ATTENTION: JASMINE TRANQUILLE, SENIOR ASSESSMENT OFFICER

**RE: STATE SIGNIFICANT RESIDENTIAL DEVELOPMENT WITH INFILL
AFFORDABLE HOUSING, PPTIES: 59-63 TRAFALGAR AVENUE AND 1A&1B
VALLEY ROAD, LINDFIELD, SSD-79276958**

WEST ELEVATION (TRAFALGAR AVENUE)

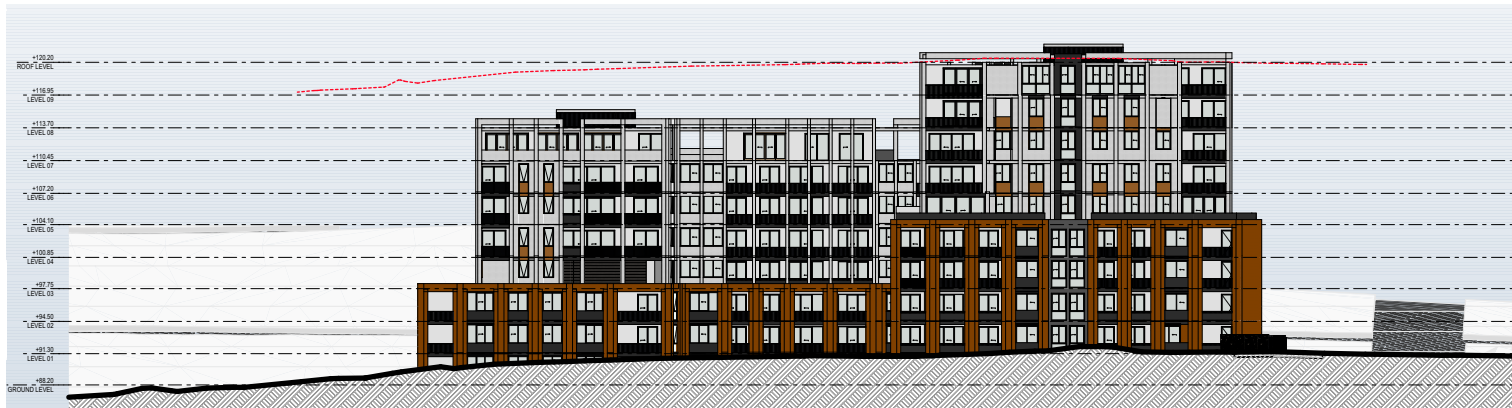
- The proposed front setback to Trafalgar Avenue is 4.5m which the EIS claims to be consistent with the prevailing front setback. No calculations are provided in the EIS to support this claim. Calculations that I have received evidence that the prevailing front setbacks of the existing dwellings on the opposite western side of Trafalgar Avenue to be approximately 7.5m. Thus, the

proposed front setback of 4.5m is inadequate. On this point, the proposed development occupies the majority of the properties on the eastern side of Trafalgar Avenue. Therefore, the prevailing front setback must be calculated based on the dwellings on the opposite side of Trafalgar Avenue. Simply put, the proposed 4.5m front setback is clearly contrary to the prevailing front setback along Trafalgar Avenue. Furthermore, the very tall front facade facing Trafalgar Avenue exacerbates the adverse Visual Impact when viewed from the street.

A.3.1 BASEMENT 2 PLAN

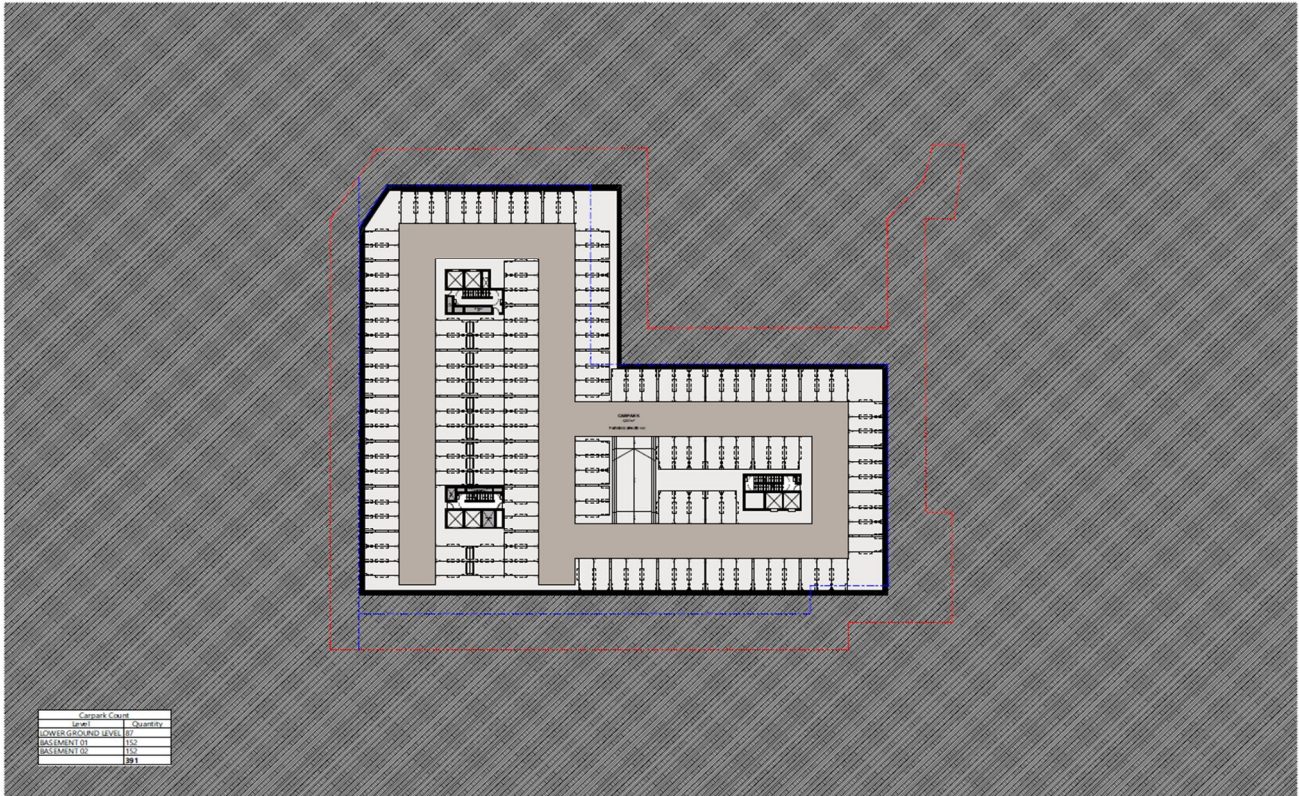
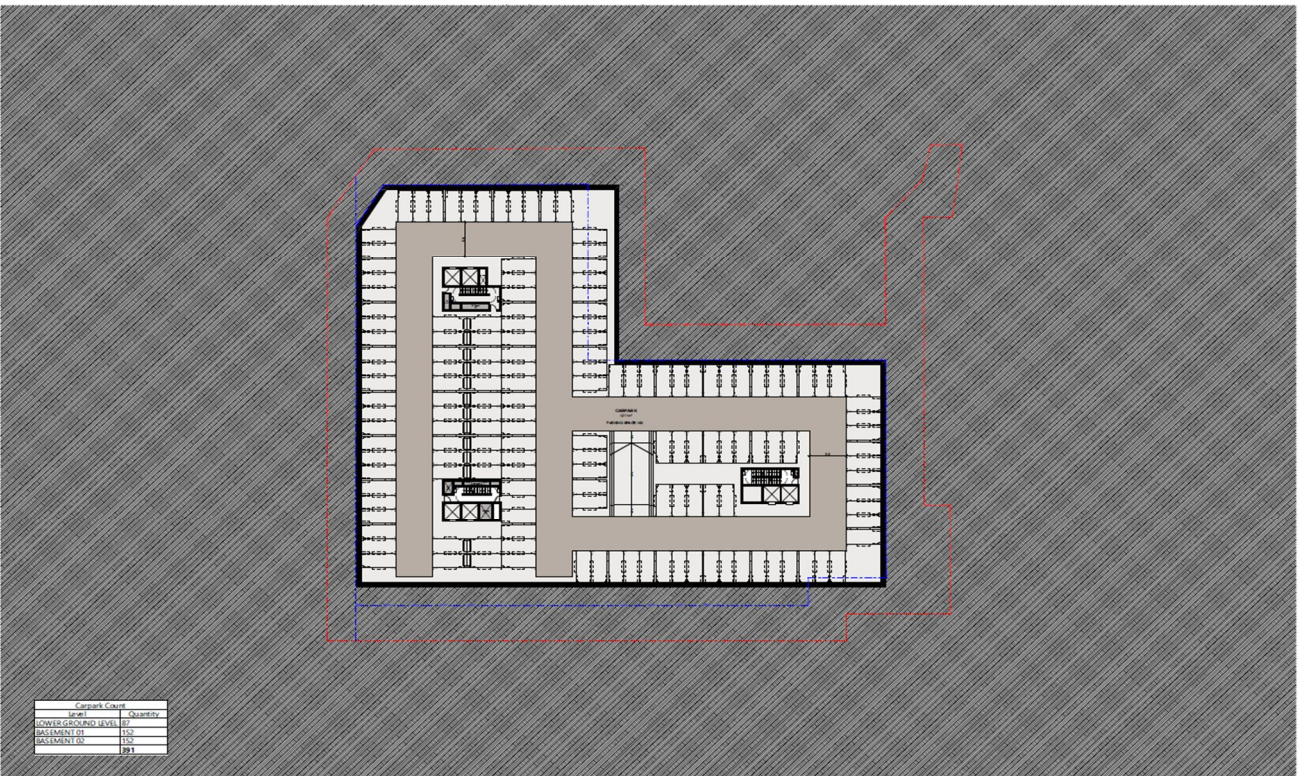
- Part of the proposed basement levels extend beyond the building footprint above. This is also contrary to the ADG.
- The fact that part of the proposed basement levels extend beyond the building footprint also diminishes the amount of Deep Soil Zone to accommodate deep soil landscaped area. Thus, the fact that part of the proposed basement levels extend outside of the proposed building envelope is a further flaw in the design.

- i. At various points of the proposed basement carparking levels, there is inadequate side setback to accommodate sufficient Deep Soil Landscaped Area.
